Our Ref: EN010147

Application by Photovolt Development Partners (PVDP) on behalf of SolarFive Ltd for an Order Granting Development Consent for the Botley West Solar Farm

Advice following issue of decision to accept the application for examination

\* Proposed Landscape areas are indicative  
 \*\* Areas of grassland beneath / not beneath solar arrays are managed through conservation grazing, and to deliver BNG

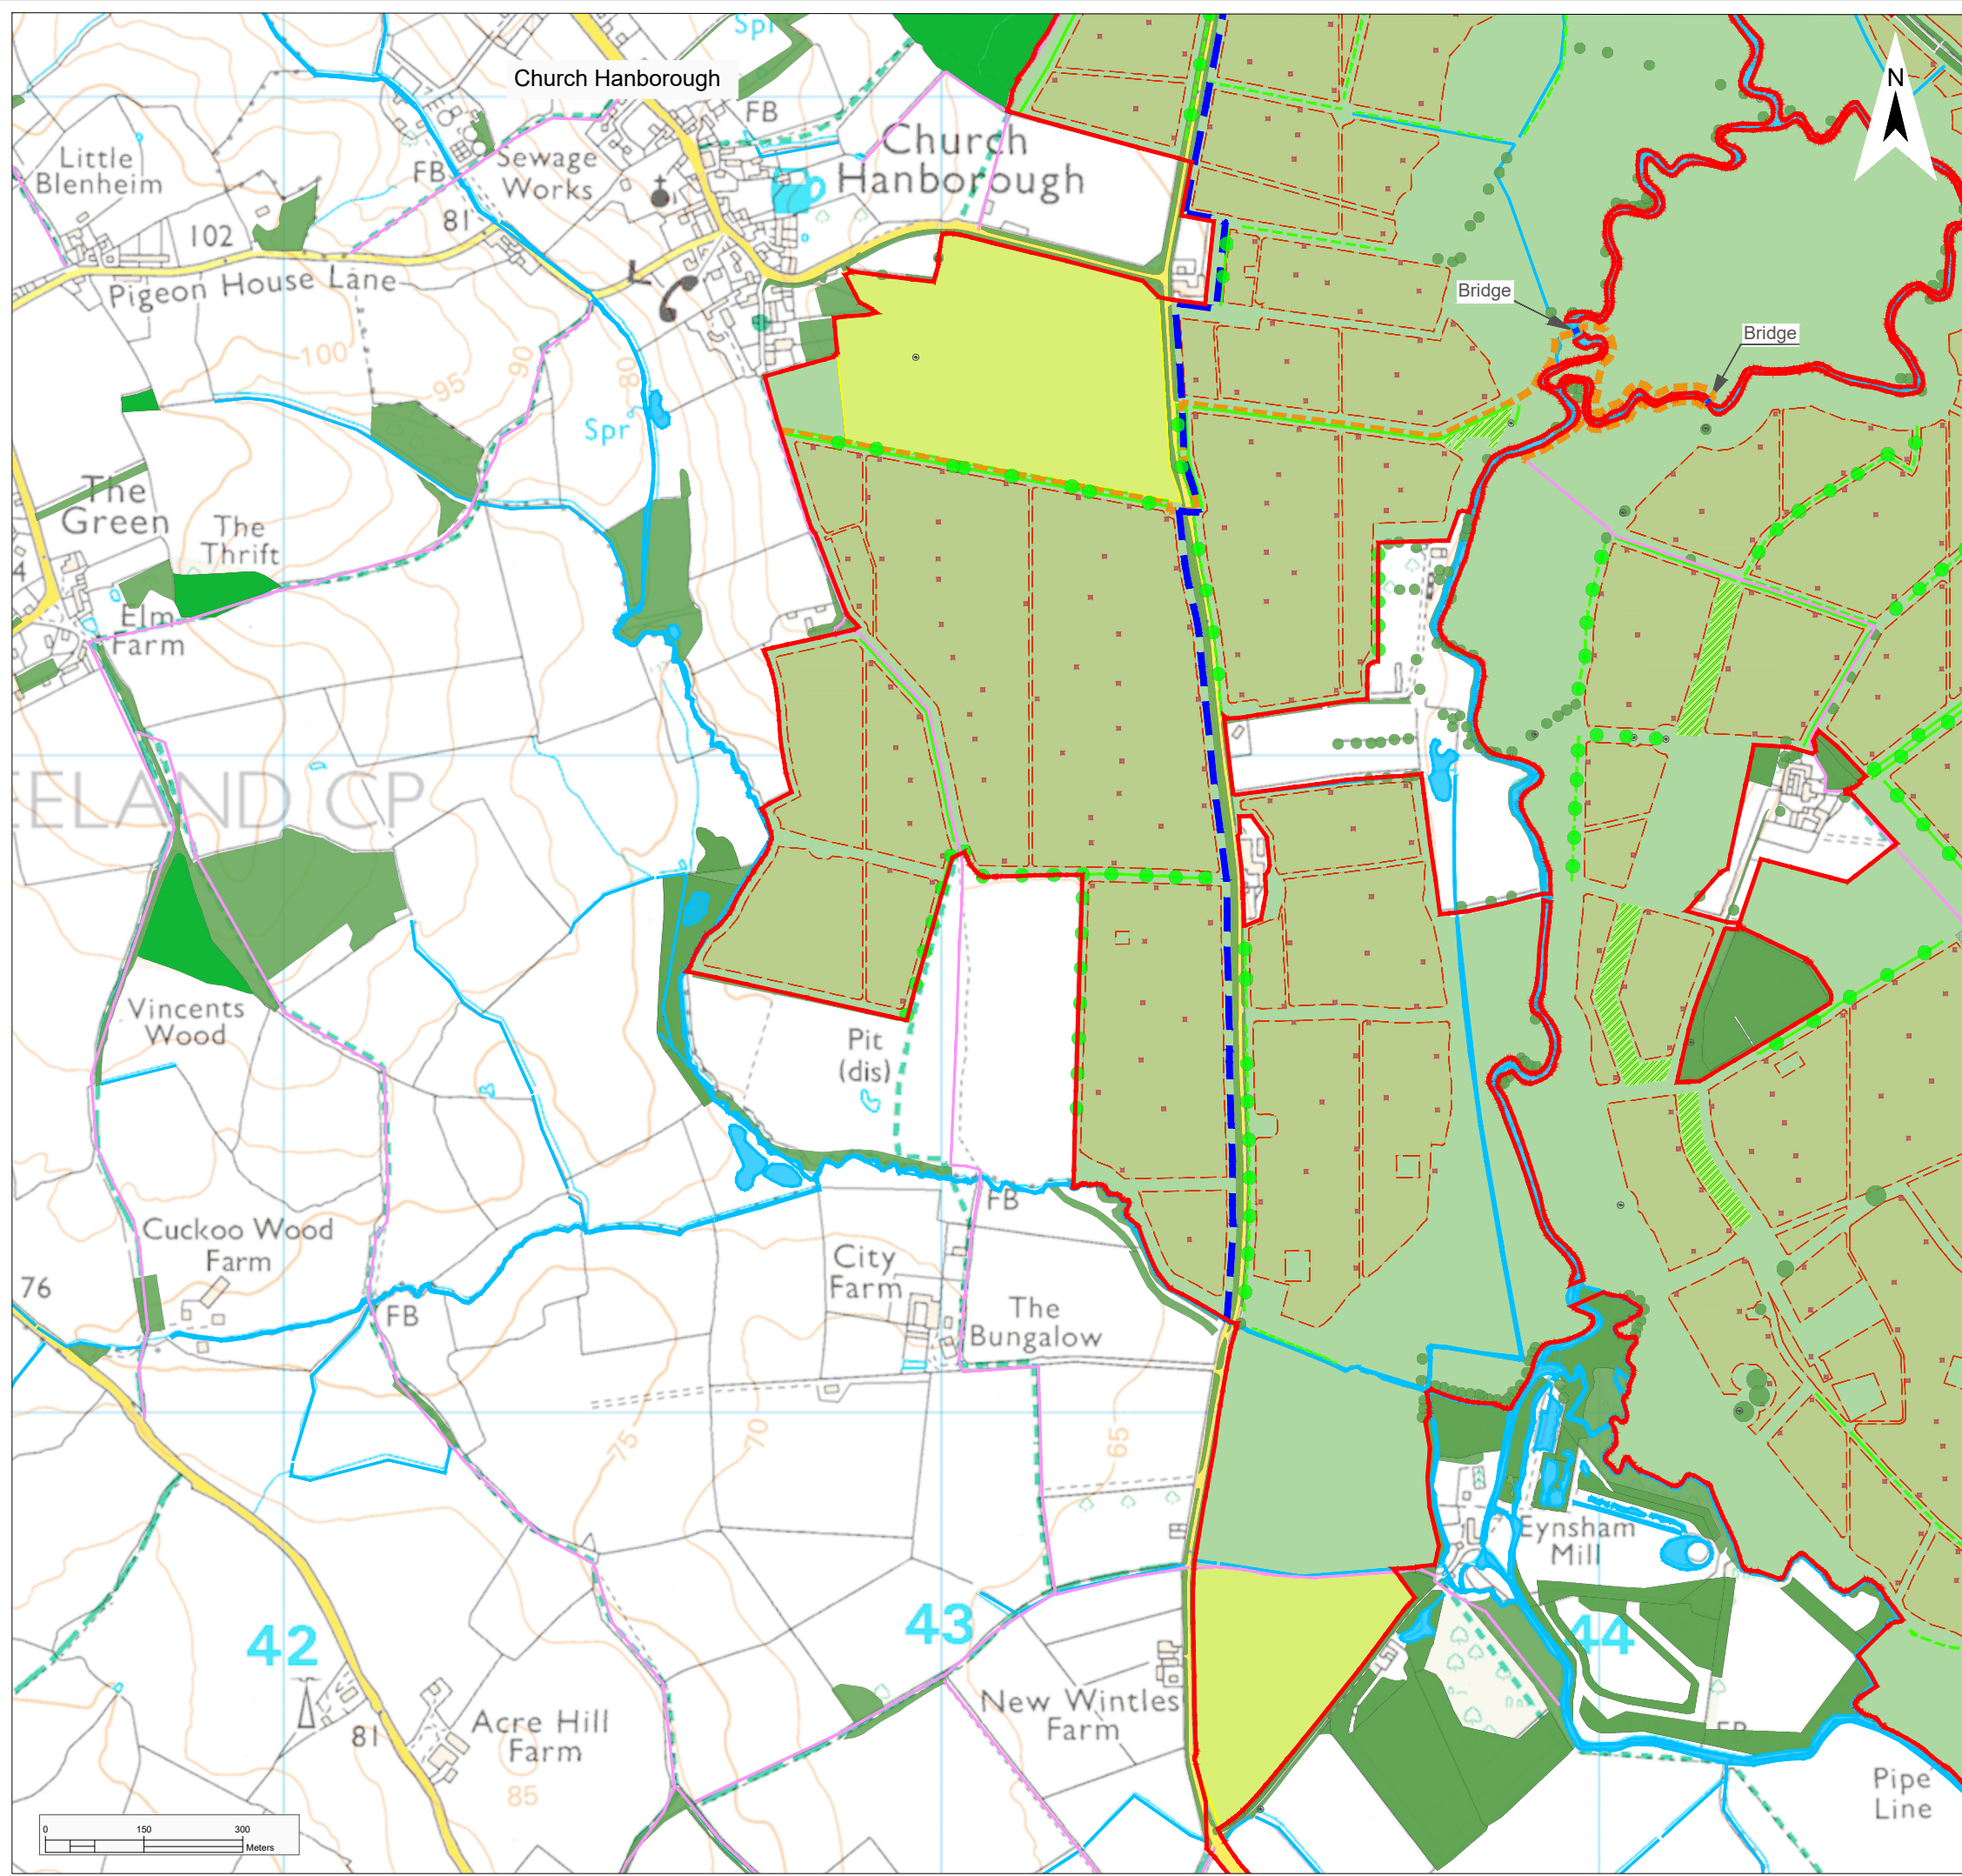
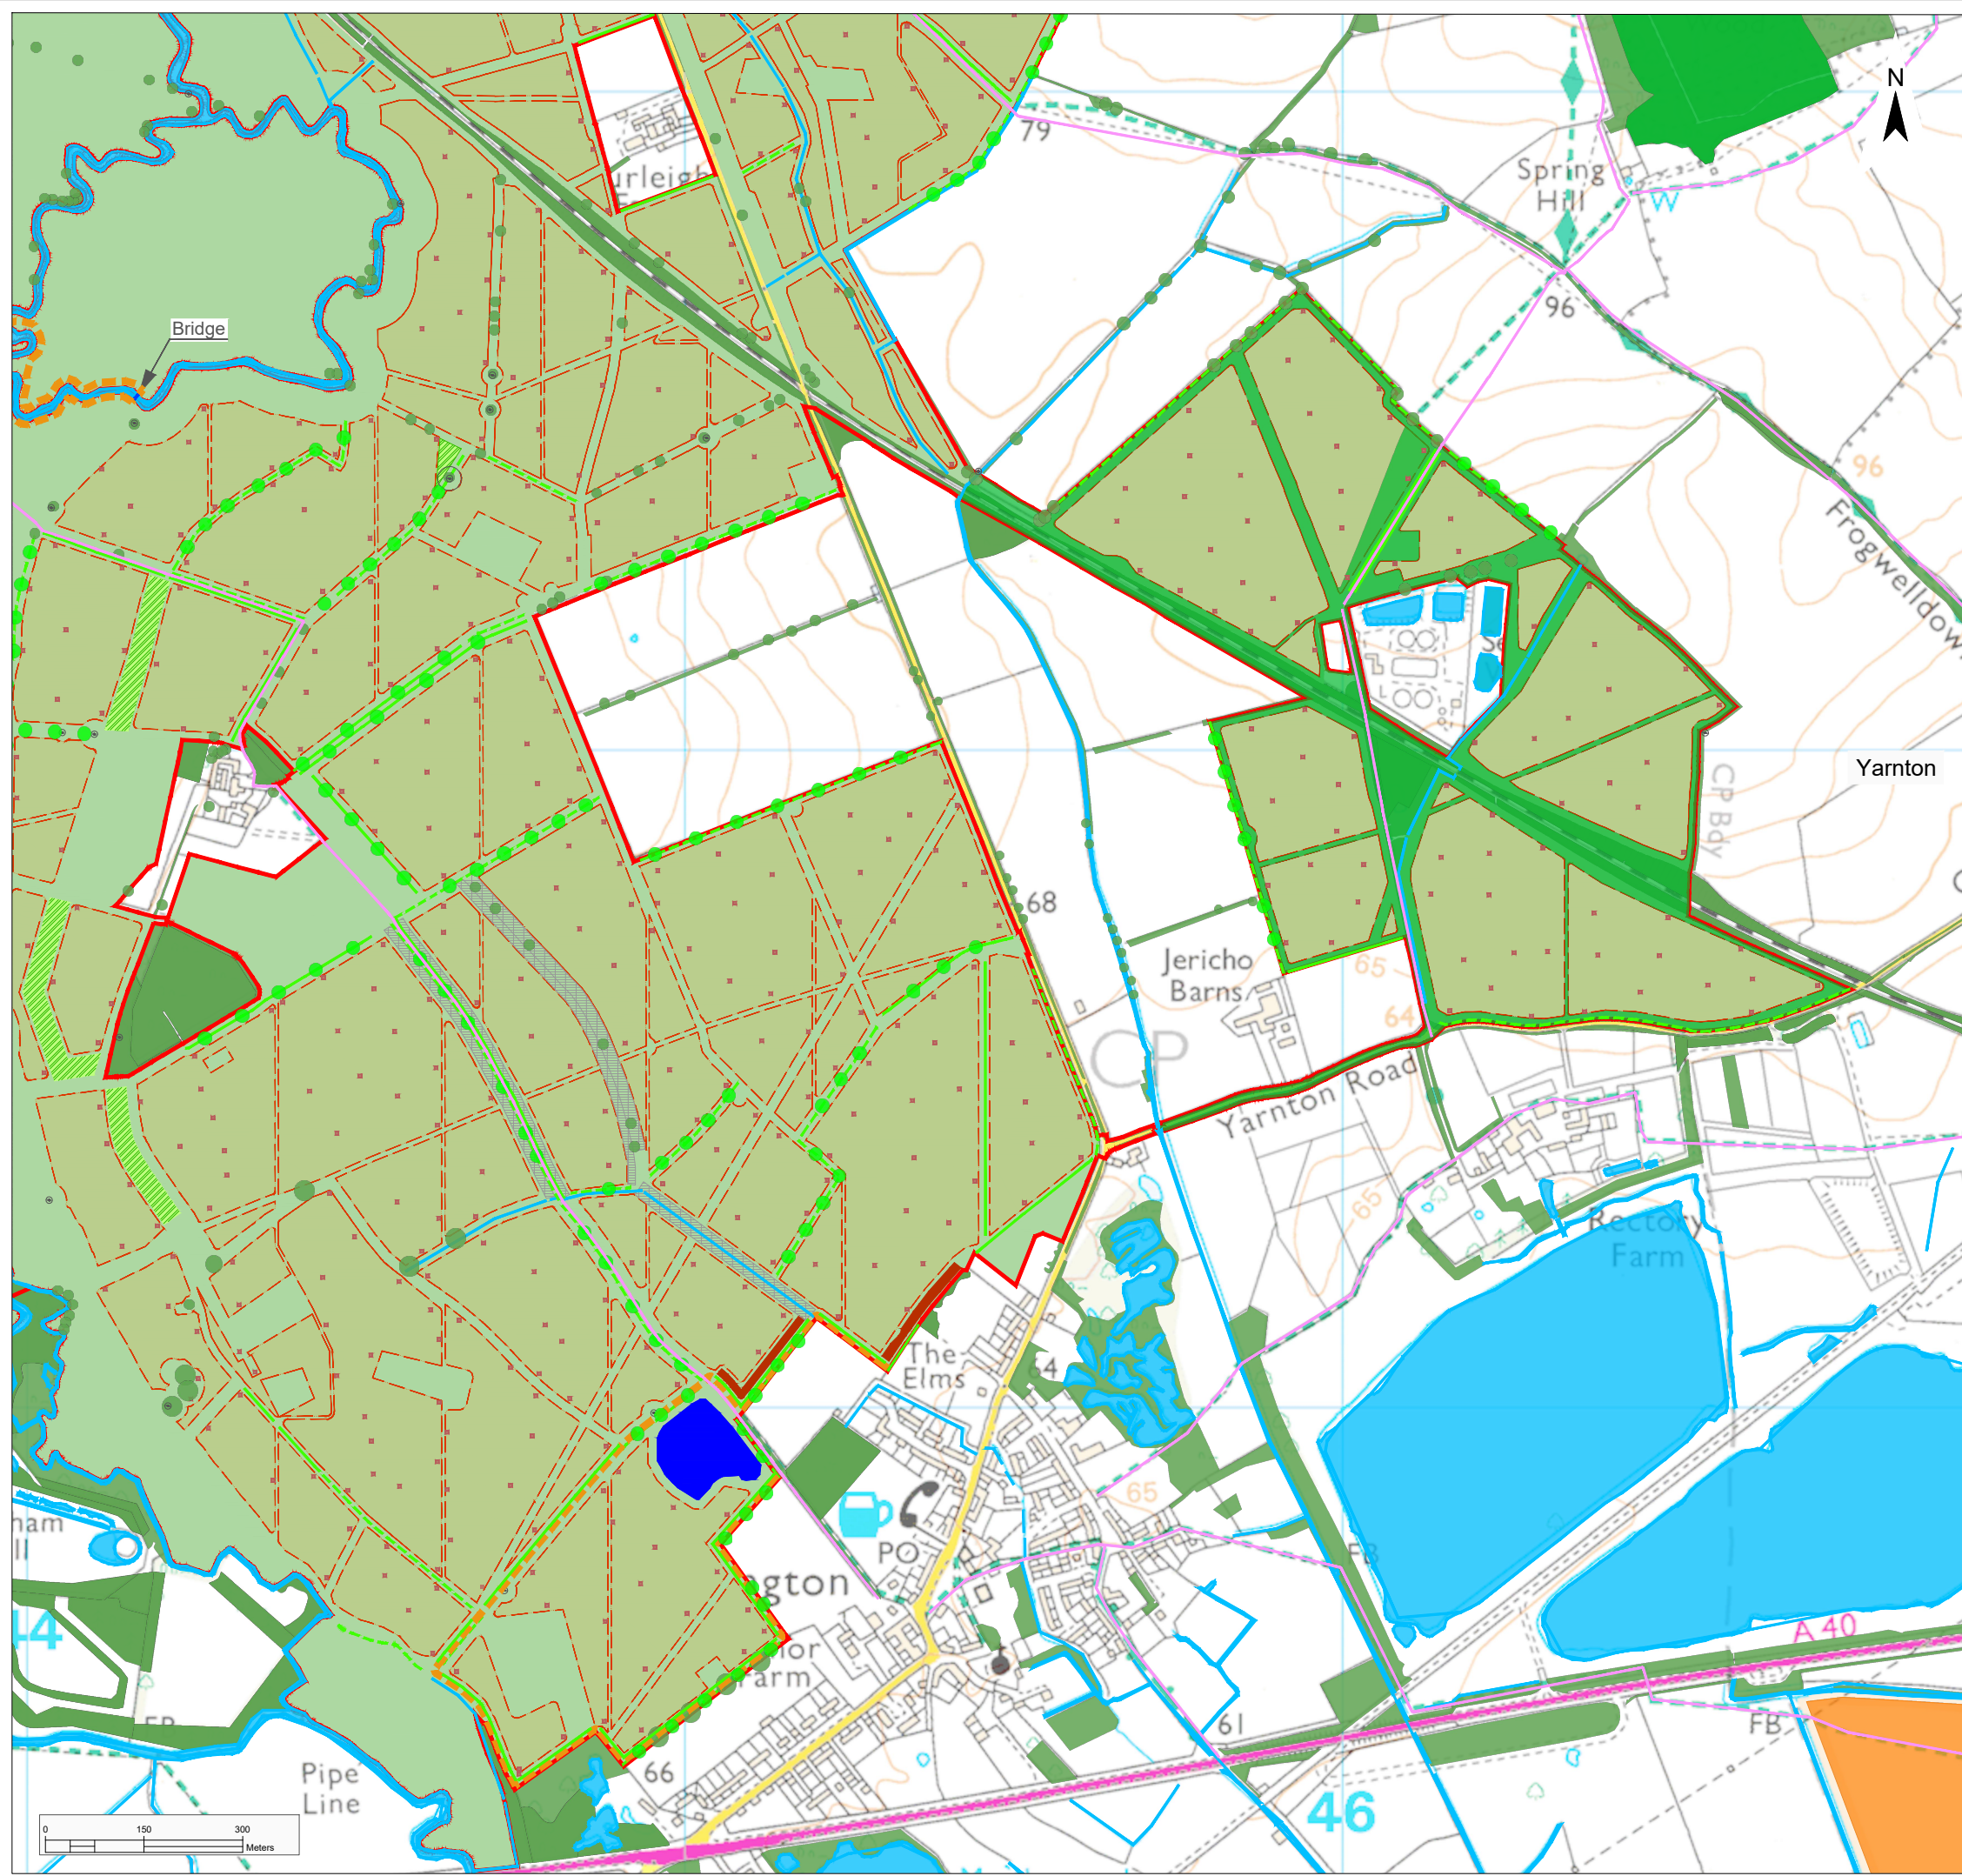
Operational Development Areas Plans (Doc 7.3.2), Landscape, Ecology & Amenities Layer Plan (Doc 7.3.3) and Temporary Facilities Plans (Doc 7.3.4)

The Inspectorate draws the attention of the applicant to APFP Regulation 5 (4A) in relation to these plan documents. The applicant may wish to amend these plans to ensure that the scale being used follows this regulation. For the benefit of the understanding of all parties to a future examination it may be desirable if it was more clearly presented on the plans which areas are within the Order Limits and how the sheet in question fits in the context of the wider site.
